**SITE PLAN**  
SCALE: 1"=40'-0"

**CATHEDRAL ROCK CHURCH**  
846 STRUTHERS RANCH RD.  
COLORADO SPRINGS, CO 80921  
EL PASO COUNTY, COLORADO

DATE: SEPT 27, 2024  
DRAWN BY: D. AGUIÑO  
PROJ. MGR: J. BUTLER  
SCALE: SEE PLAN  
APPROVED BY:  
JOB NO: 1374

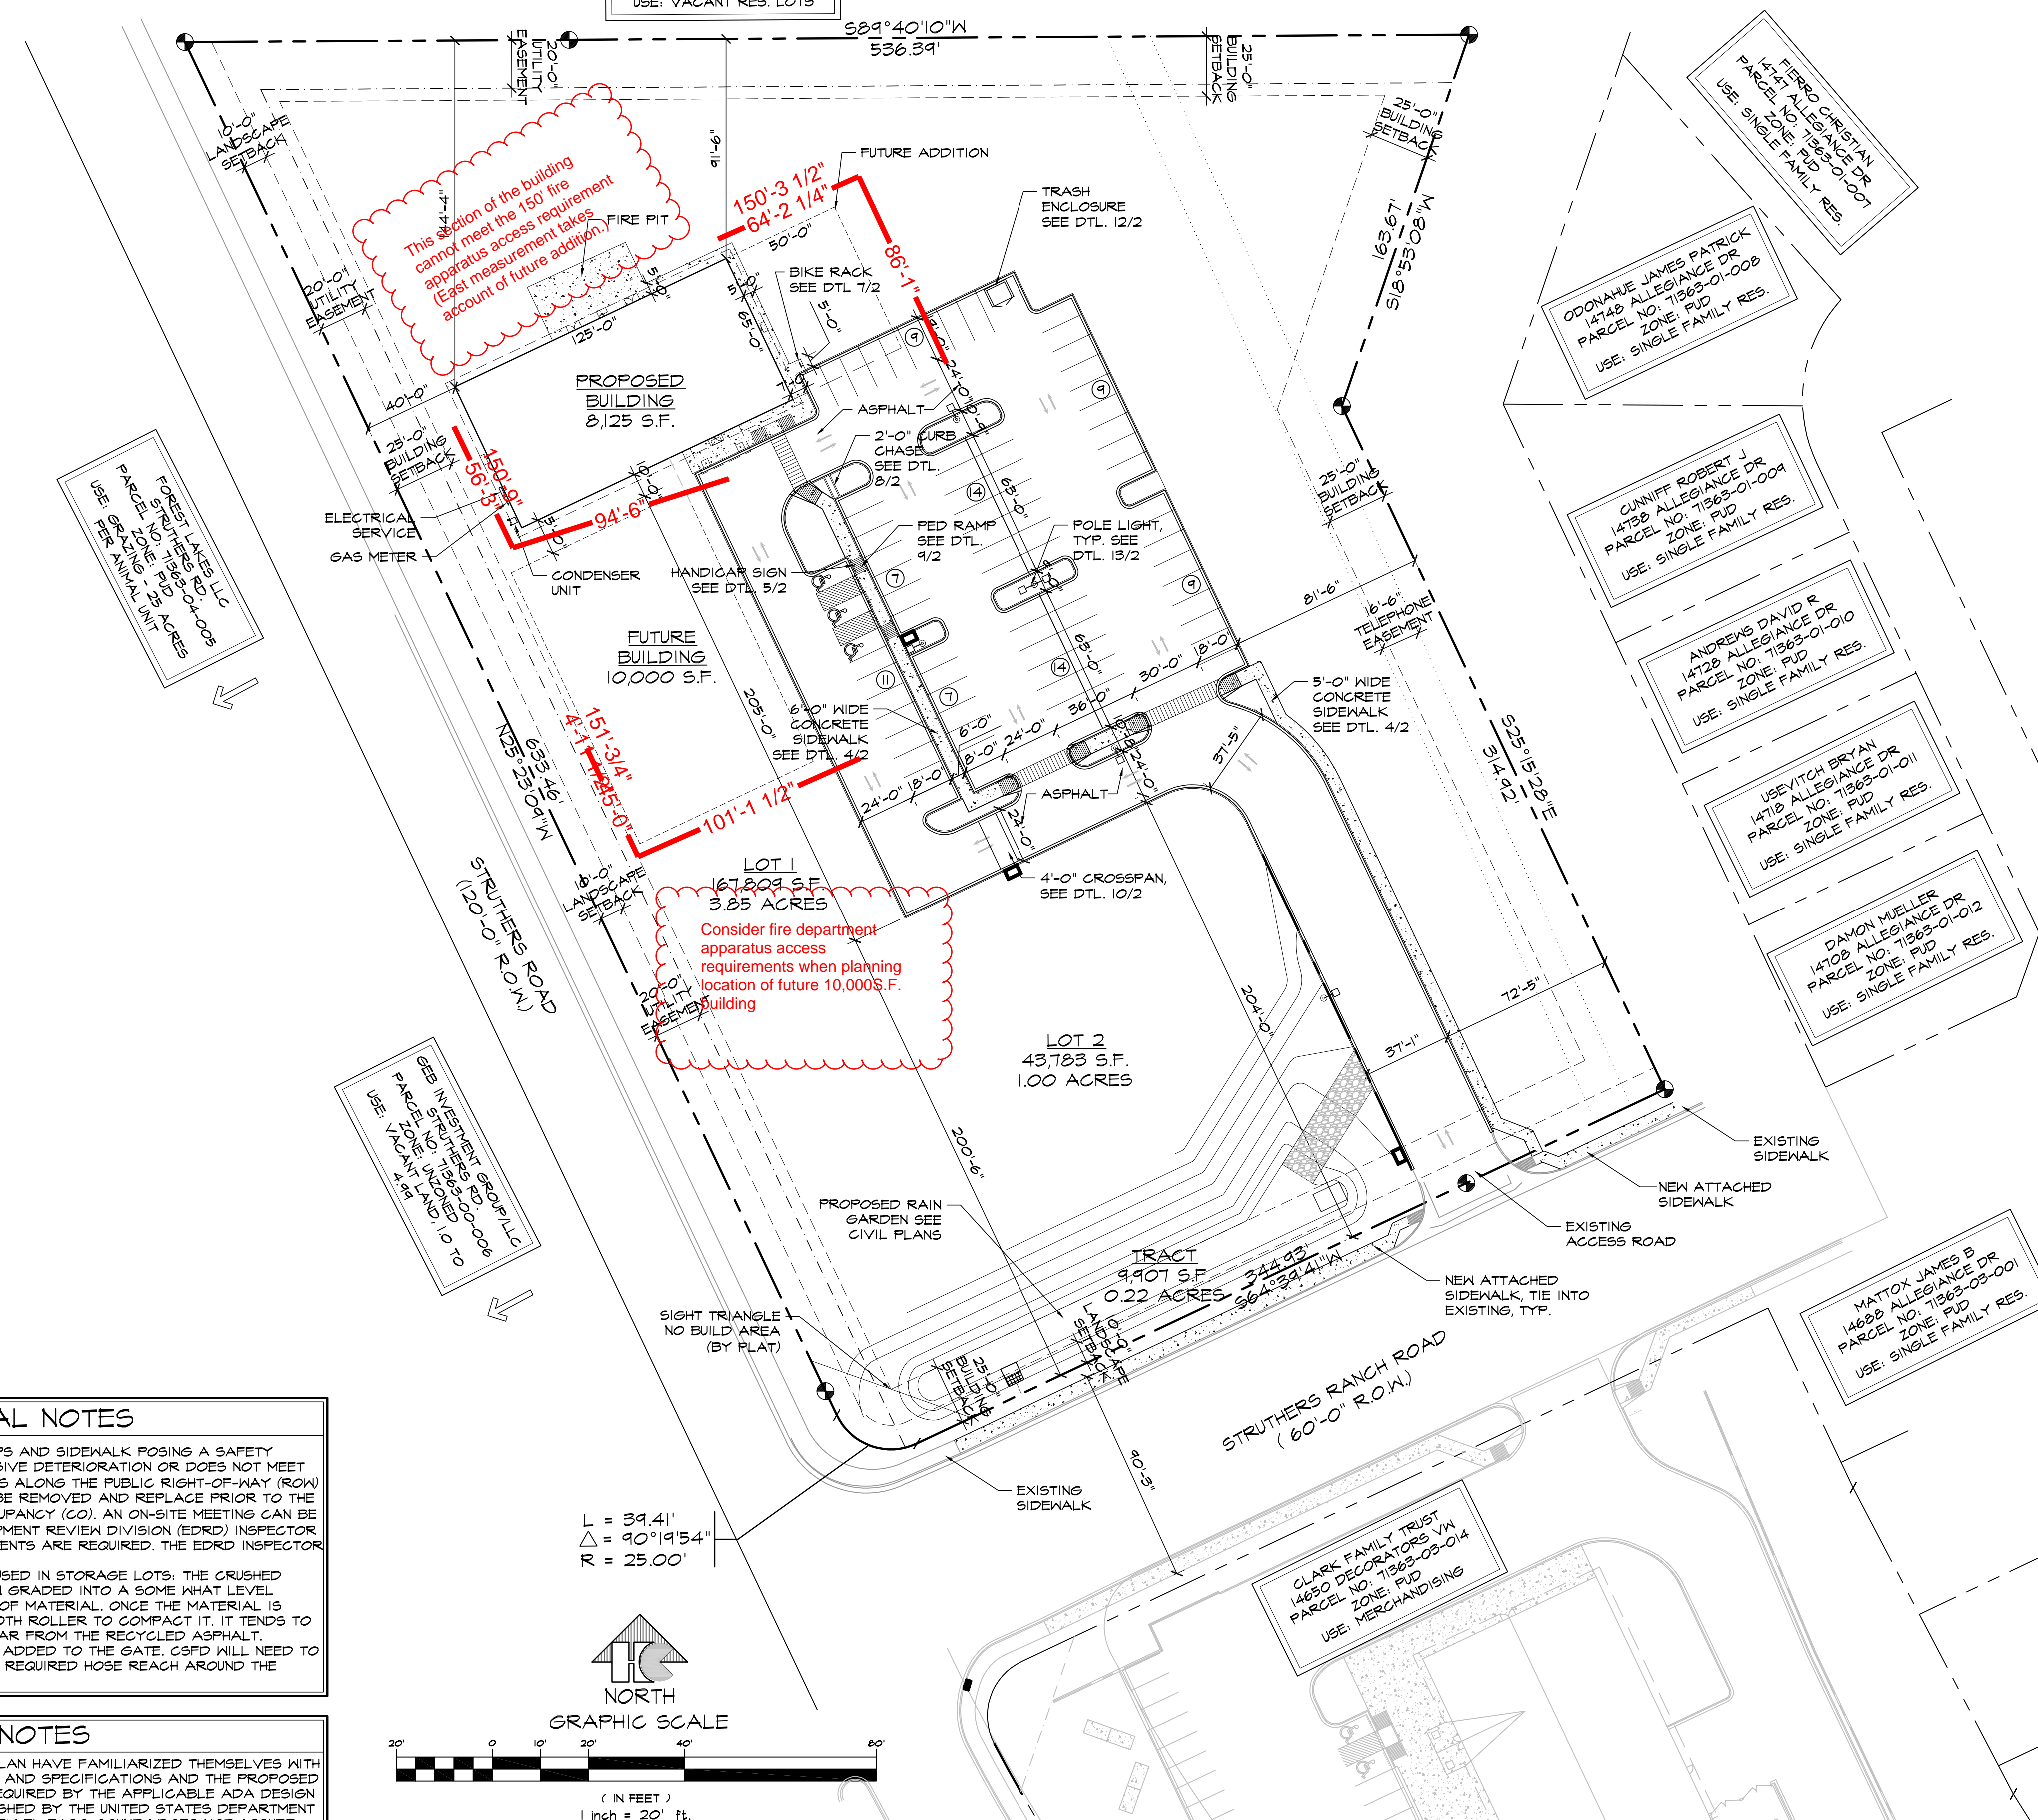
Please include a label for the ROW

Prefer to locate handicap spaces closer to main entrance with access to entry walkway

Please remove, this is not being reviewed with this submittal

Add: Signature block for the Planning and Community Development Director a minimum of 1 inch by 2 inches

Add note:  
The owner agrees on behalf of him/herself and any developer or builder successors and assignees that Subdivider and/or said successors and assigns shall be required to pay traffic impact fees in accordance with the El Paso County Road Impact Fee Program Resolution (Resolution No. 19-471), or any amendments thereto, at or prior to the time of building permit submittals. The fee obligation, if not paid at final plat recording, shall be documented.

9 PEDESTRIAN RAMP DETAIL D-8J
SCALE: 3/16"=1'-0"

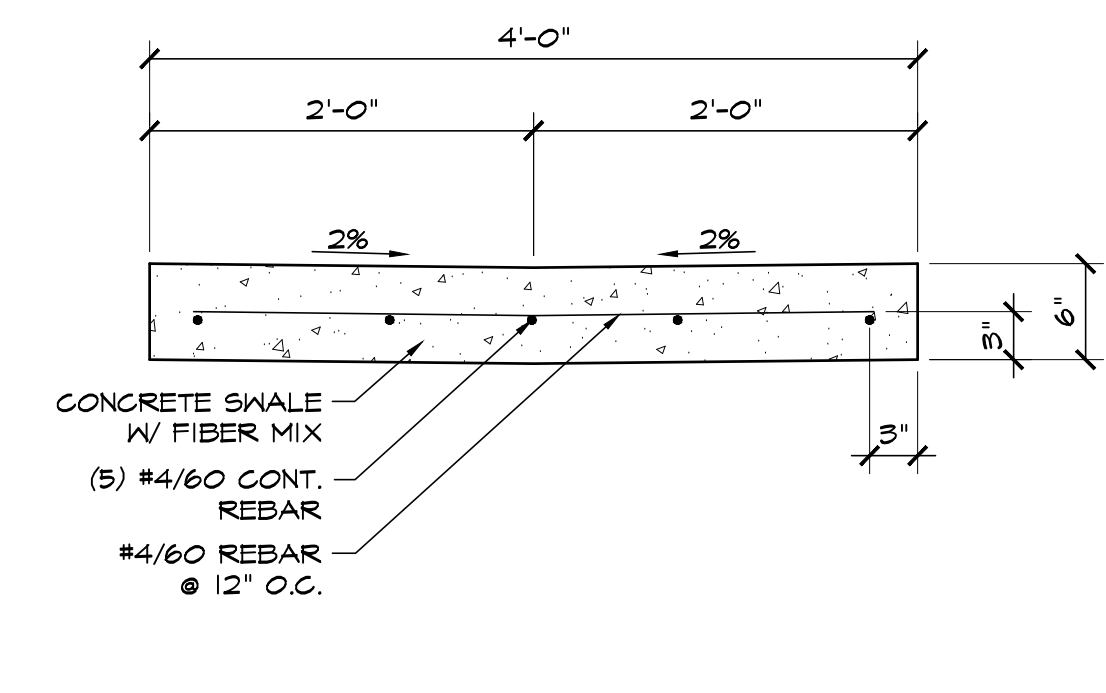
Include ECM details SD 2-40 and SD 2-41 for curb ramps

10 4'-0" CROSSSPAN DETAIL
SCALE: 1"=1'-0"

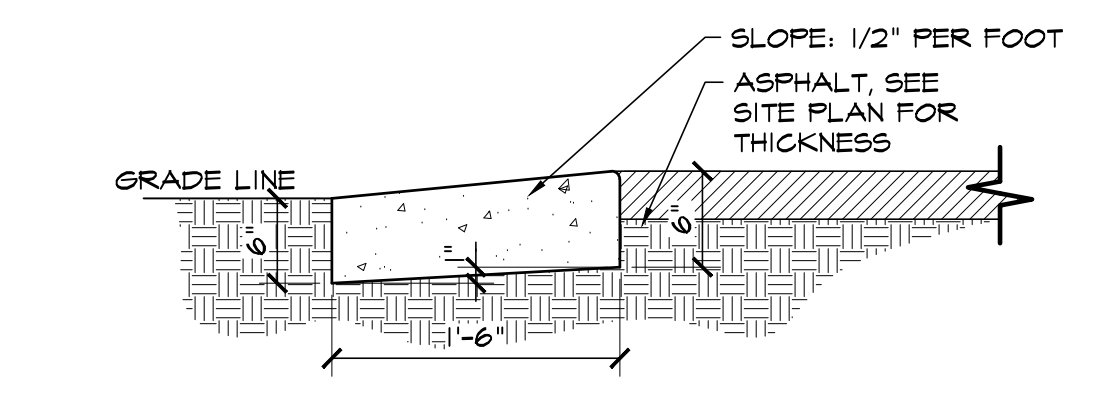
Please include ECM detail SD 2-26 for cross pan
